From: Nick Goddard
Sent: 03 January 2019 10:53
To: DCAdmin
Subject: 2018/94068 - 24 Butterley Lane, New Mill

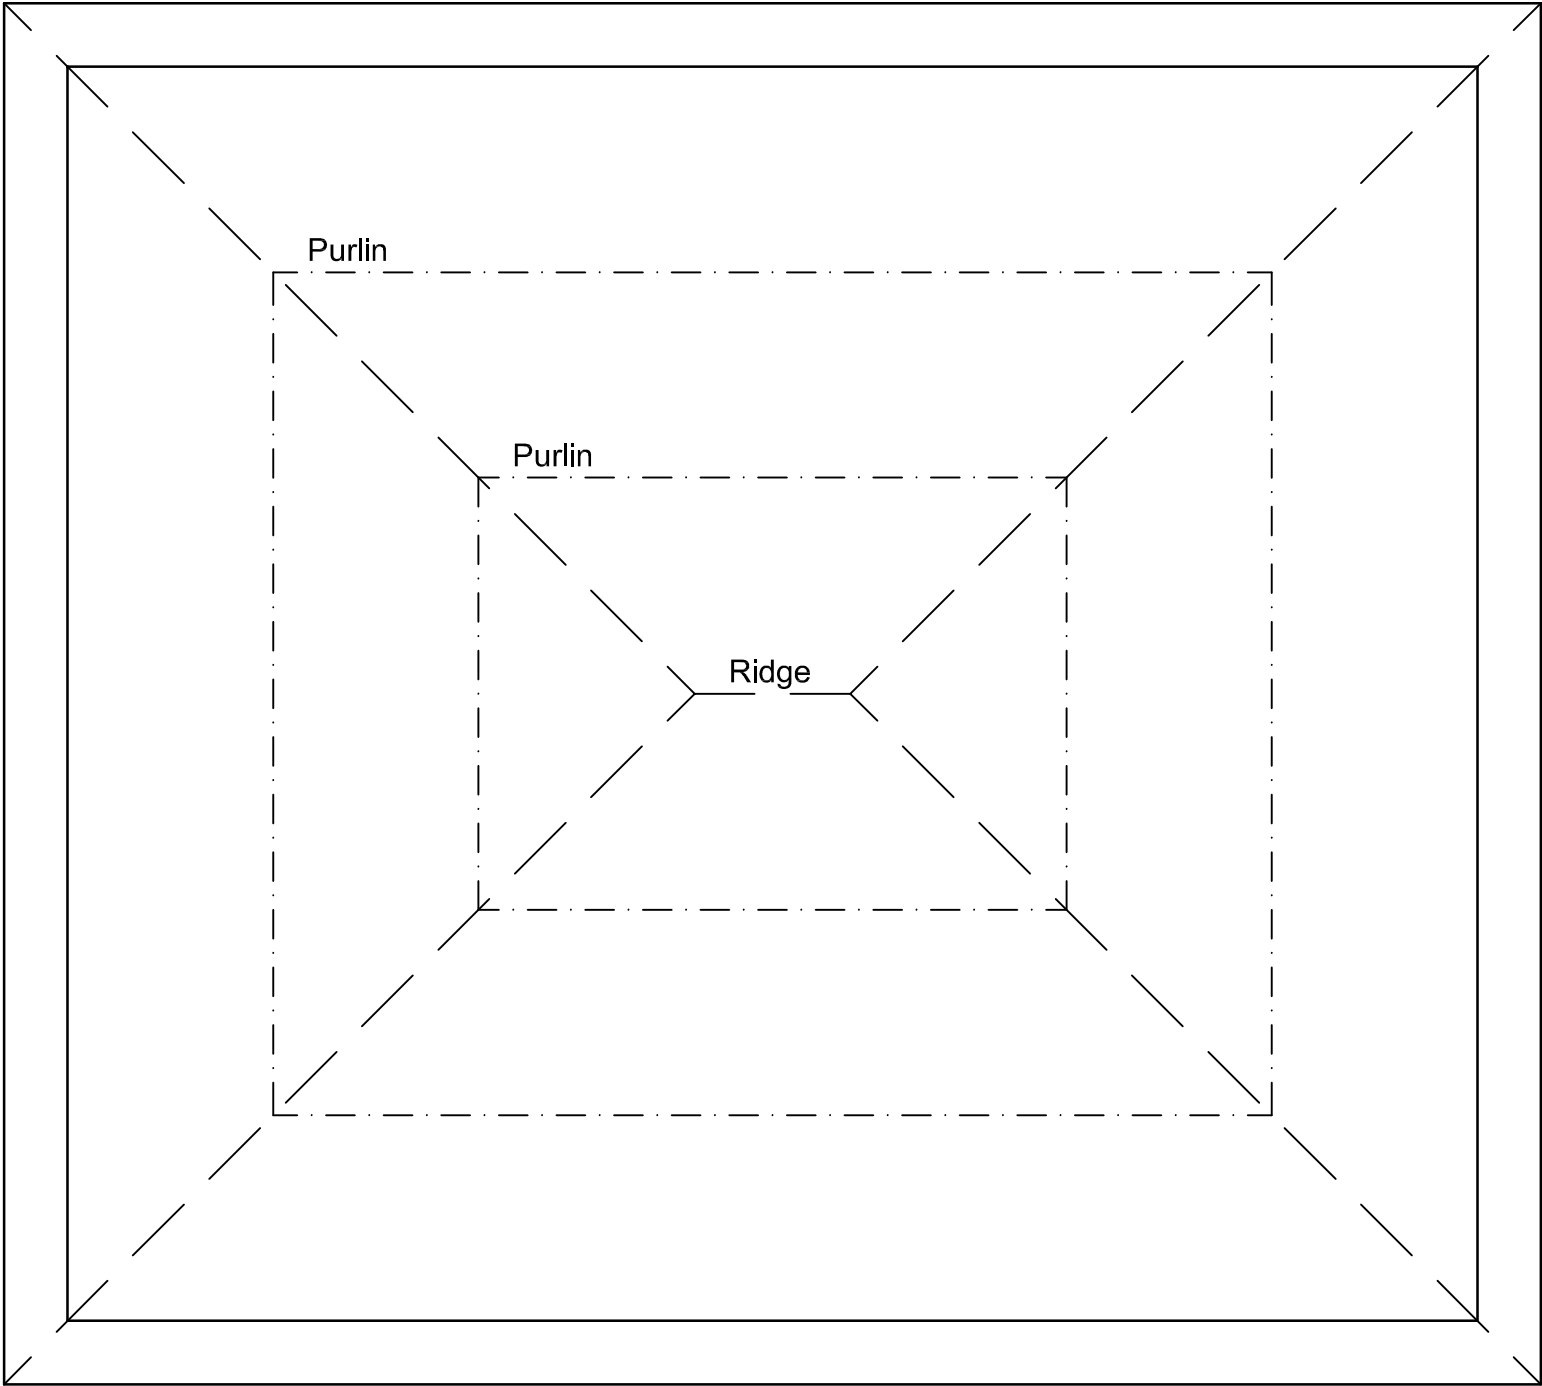
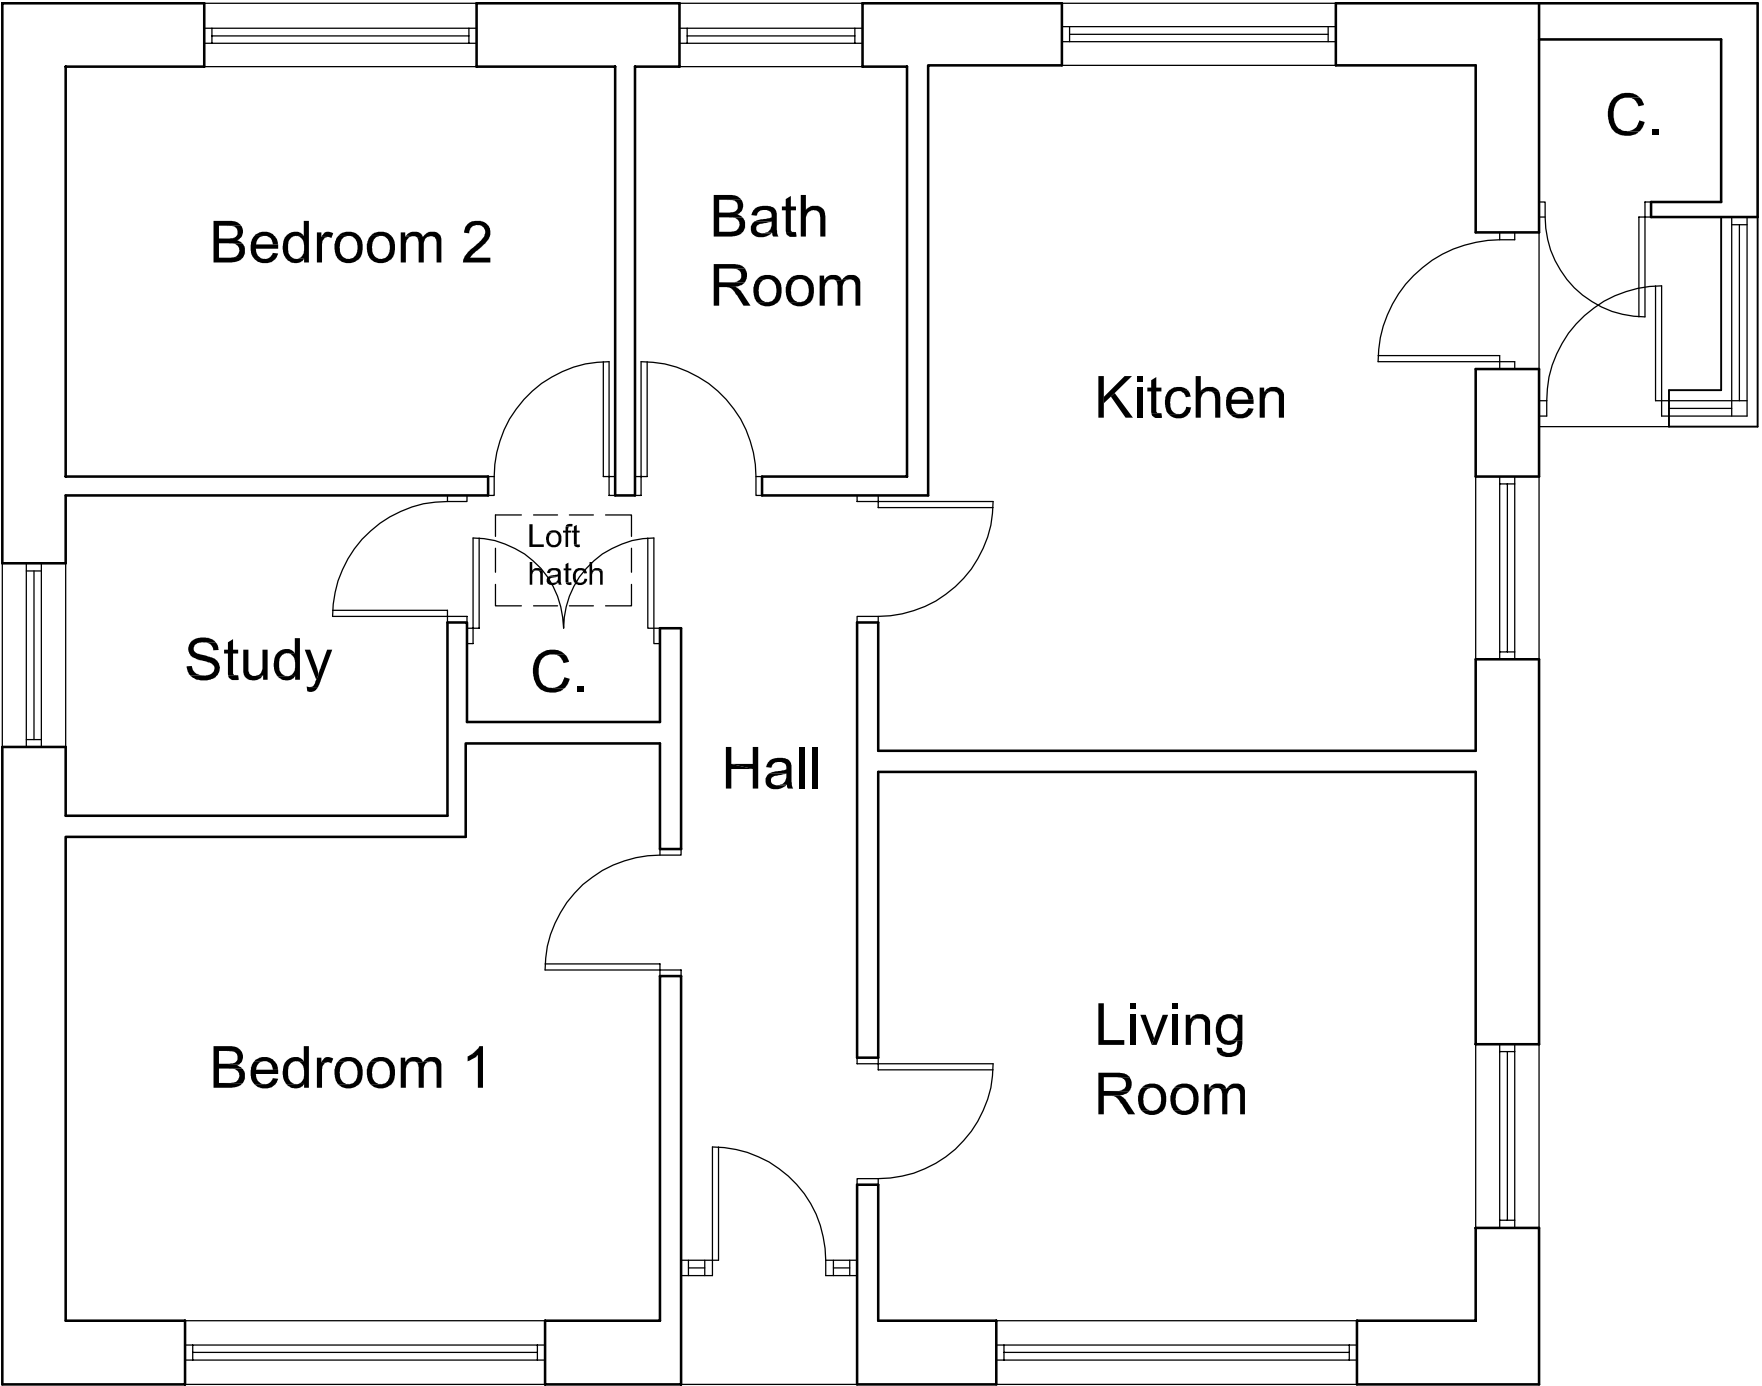
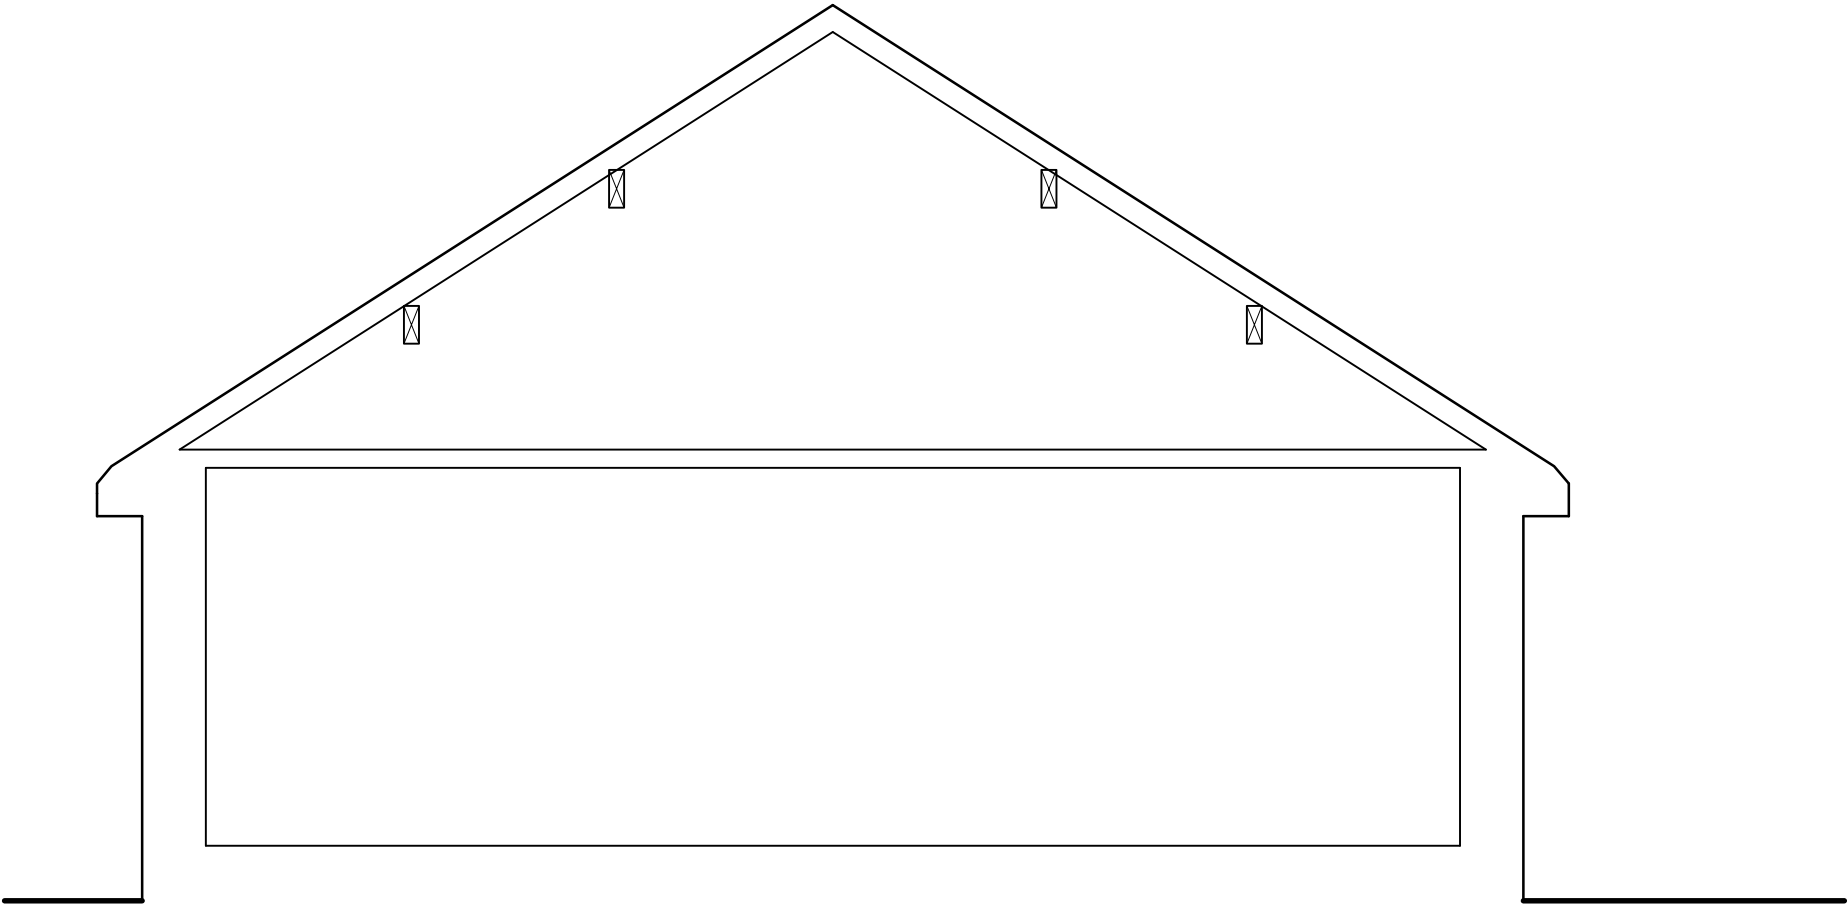
No tree information has been provided with the application making it difficult to assess. The adjacent trees are protected by a TPO and therefore their protection and long term viability is important. There are two large trees in close proximity to the location of the new garage and it is unclear how this is to be constructed without causing damage to these adjacent trees.

The proposed garage is within the root protection area of the trees and therefore normal foundations for the garage may cause significant damage. I would like to see details of how the garage is to be constructed and how the adjacent trees will be protected during this work. Could you request an Arboricultural Method Statement and Tree Protection Plan to be supplied in order to address this?
